REQUEST

Current Zoning: I-2 (General Industrial)
Proposed Zoning: UR-2(CD) (Urban Residential, Conditional), MUDD(CD)
(Mixed Use Development District, Conditional)

The petition proposes to redevelop a site currently occupied by a childcare center with up to 116 single family attached residential dwellings and 12,000 square feet of non-residential uses.

Sere Ventures, LLC

SHEET NUMBER **RZ-02**

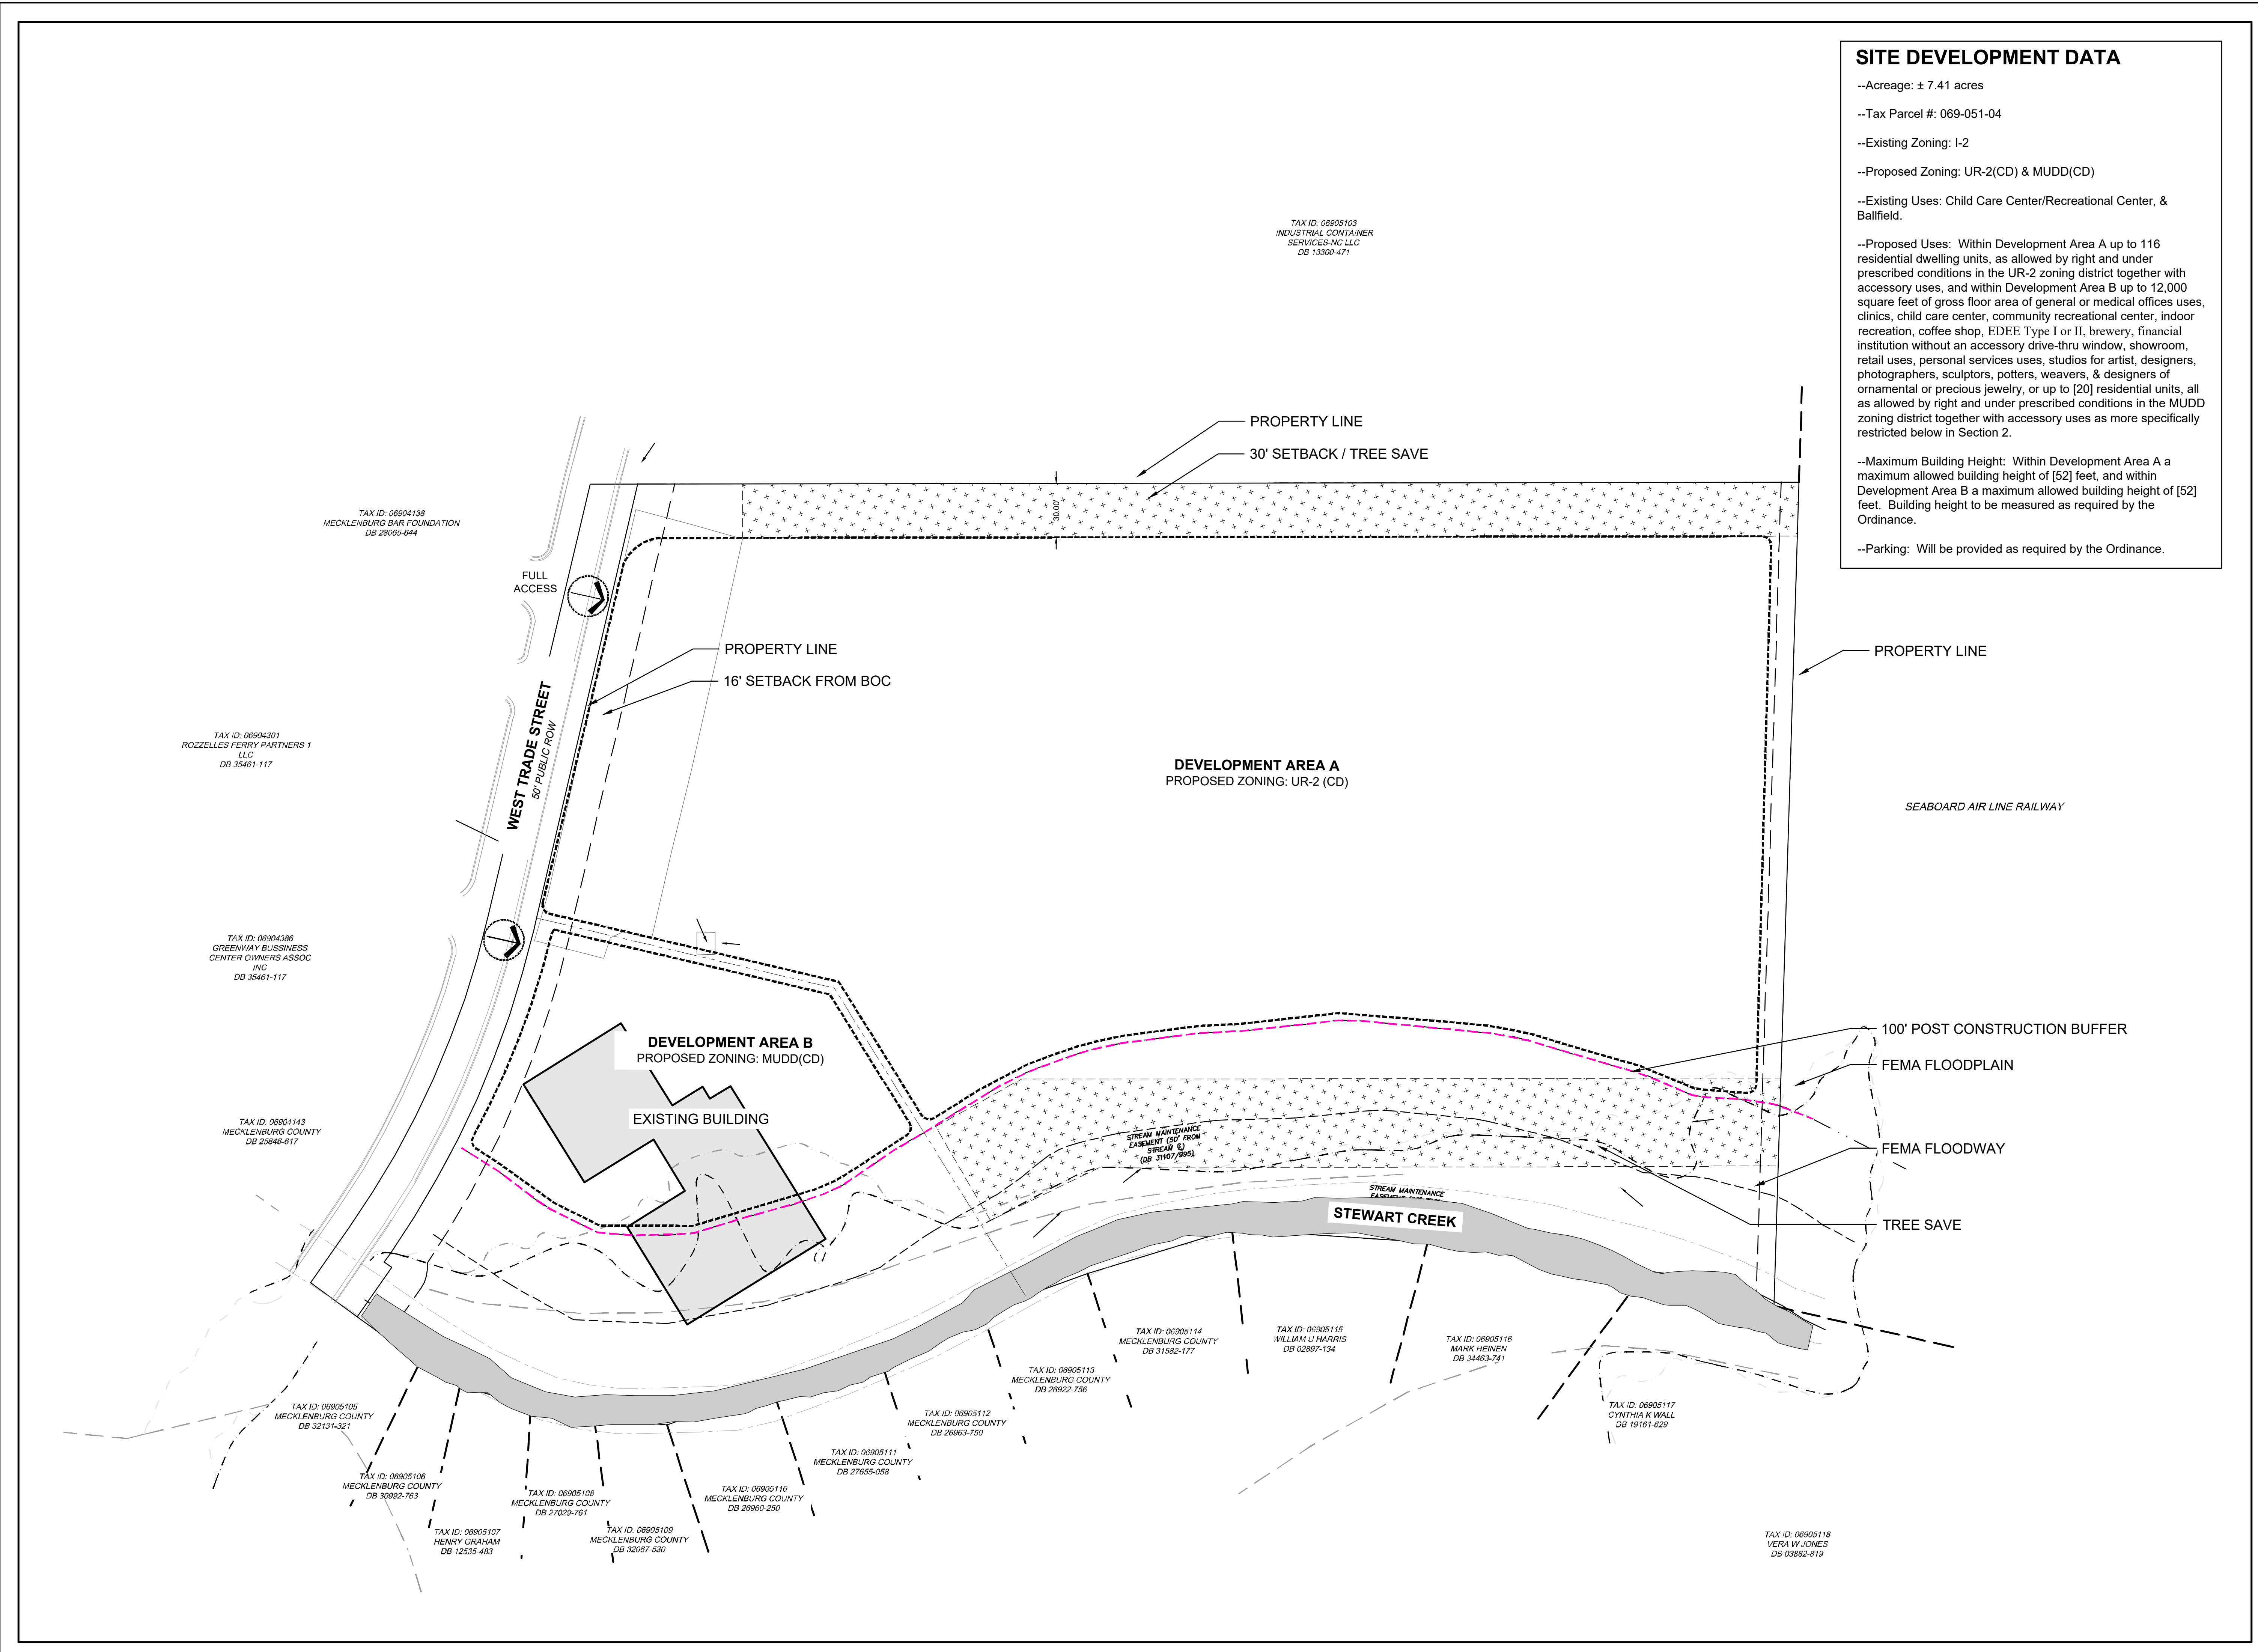
- ~~1. Revise the site plan to show a 100' greenway easement dedication except where the building is located within the SWIM buffer.~~ **ADDRESSED**
- ~~2. Revise the site plan to include an easement between the 100' greenway easement and internal sidewalk network.~~ **ADDRESSED**
- ~~3. Wrap internal sidewalk around the northeastern most building to improve connection to open space.~~ **ADDRESSED**
- ~~4. Remove note 4.c regarding side and rear yards.~~ **ADDRESSED**

7. ~~Commit to preserving a minimum of 25' 30' along the western property boundary as tree save or label as a 25' Class A buffer. Tree save must be a minimum of 30' in width.~~ ~~ADDRESSED~~

RZ-02

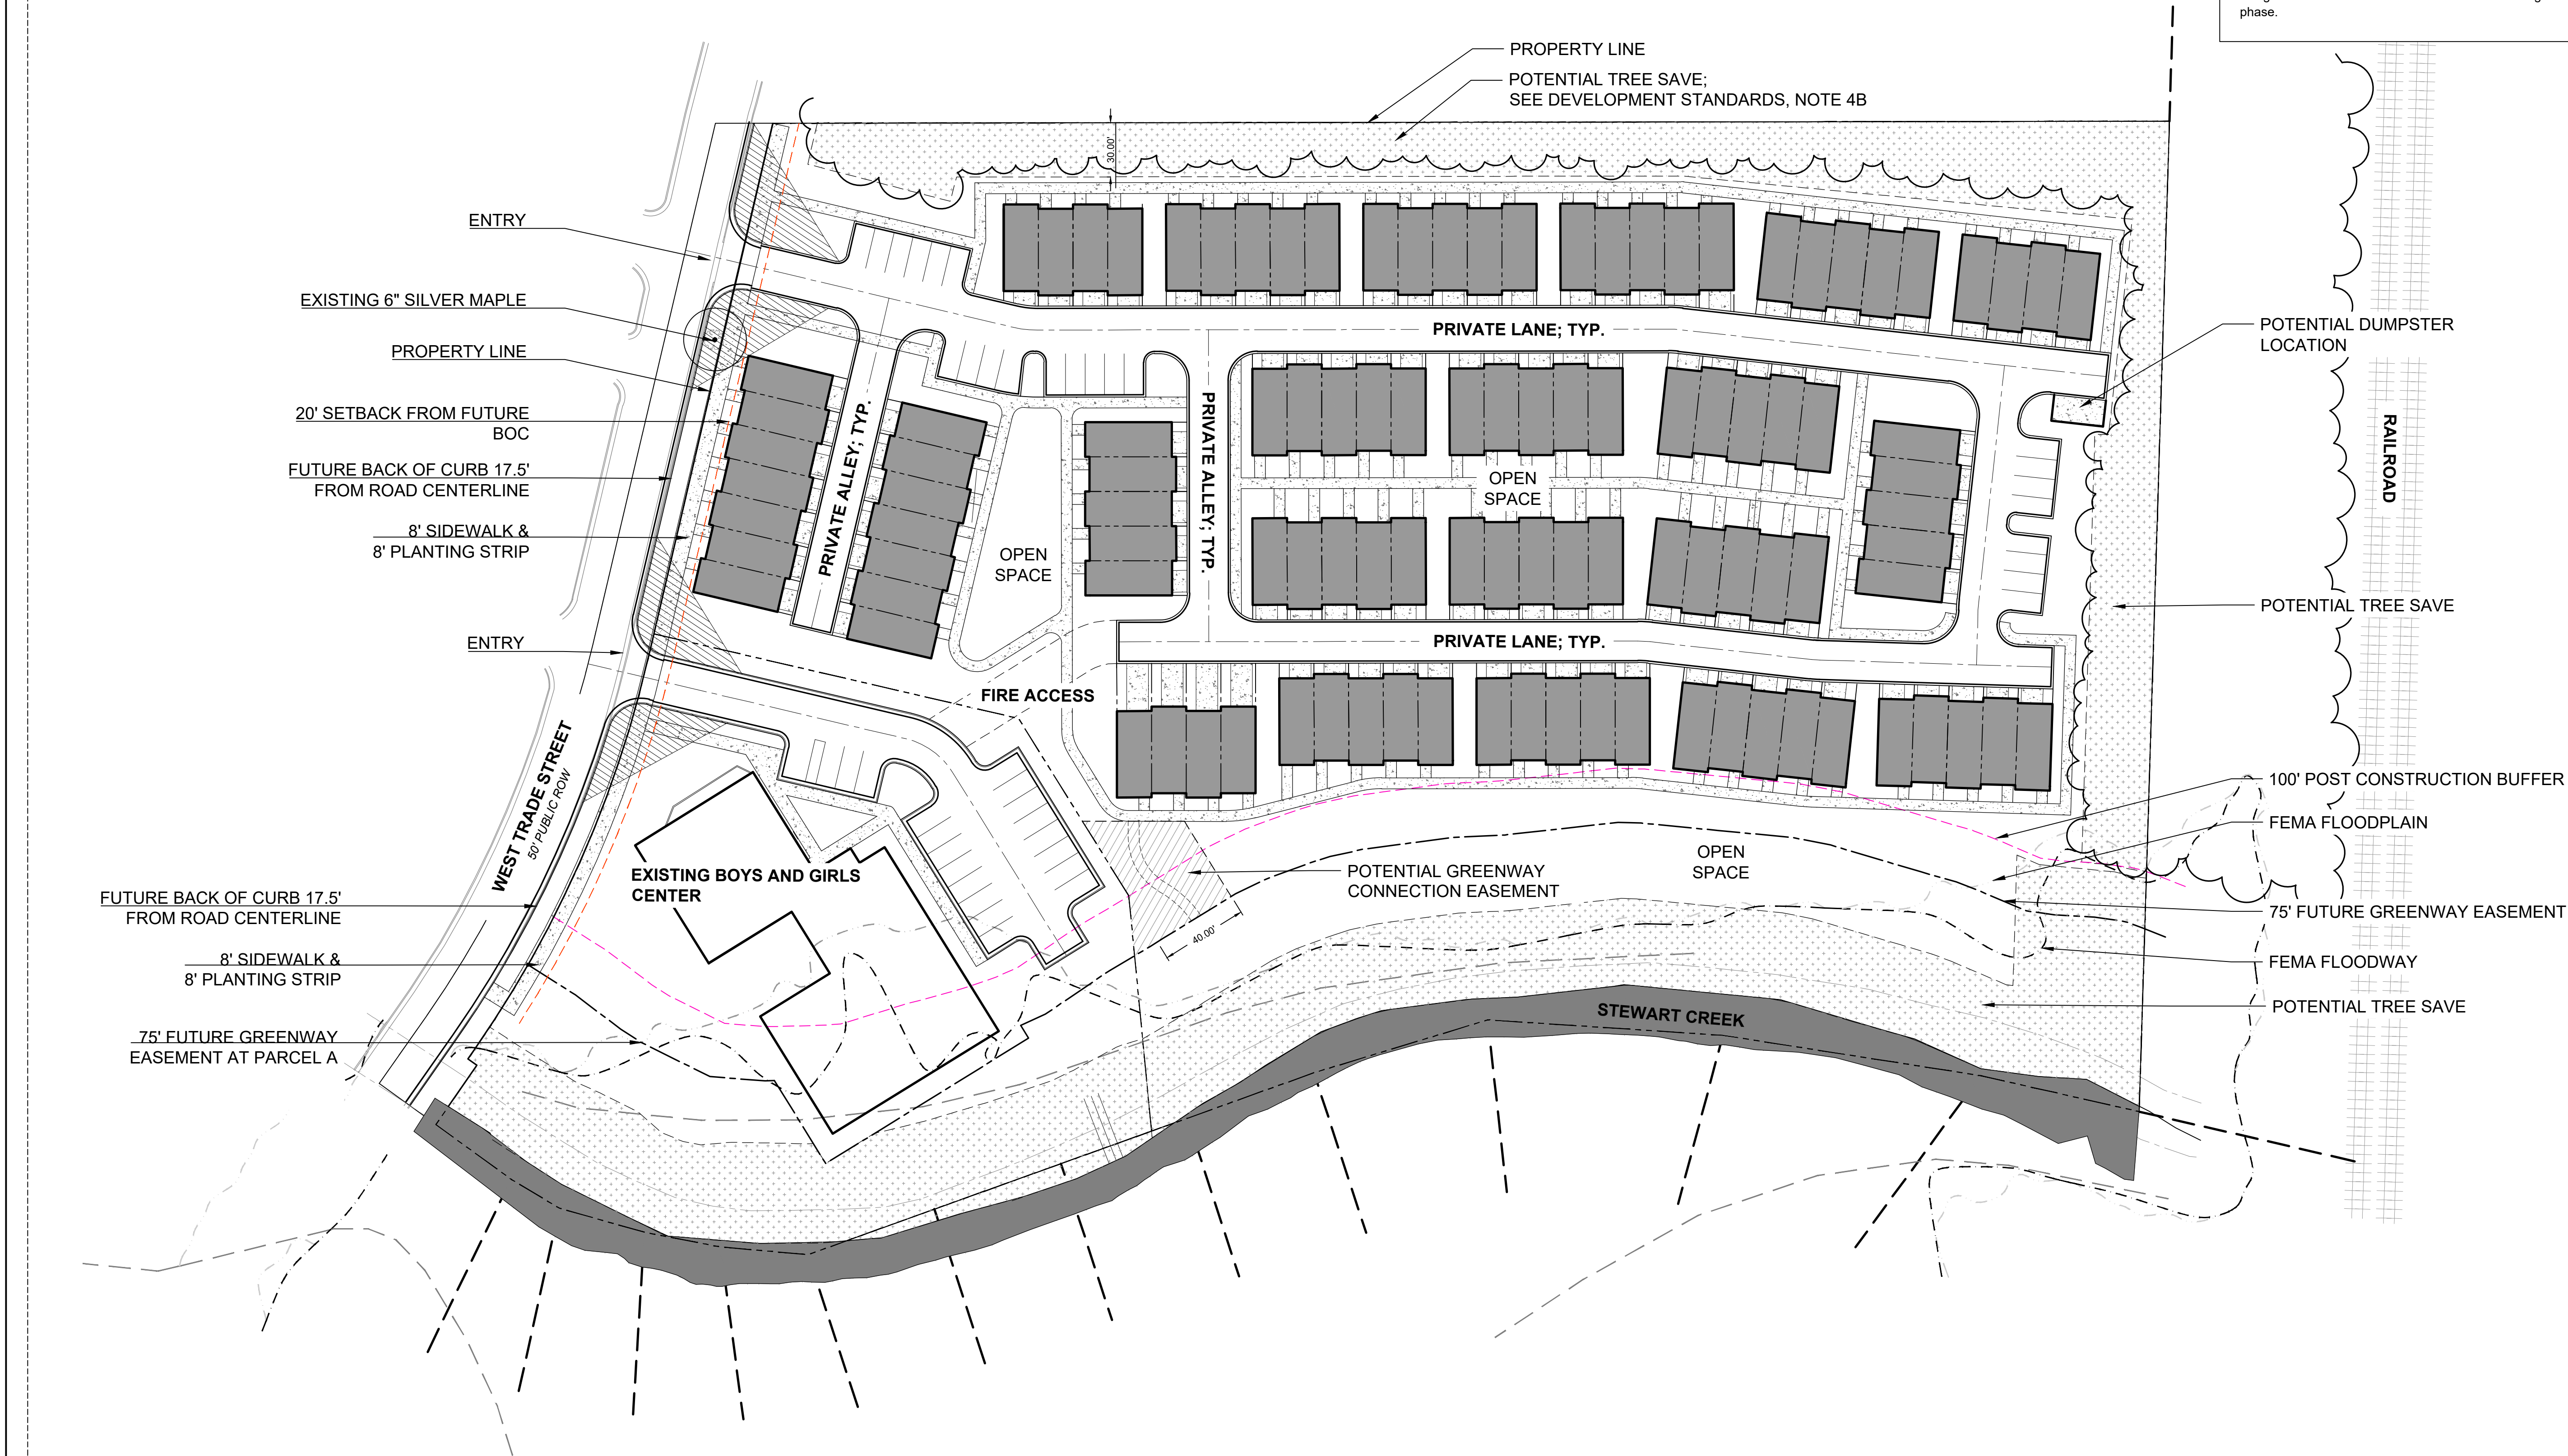
11. ~~Ensure that tree shown in right of way matches existing conditions.~~ ~~ADDRESSED~~
-
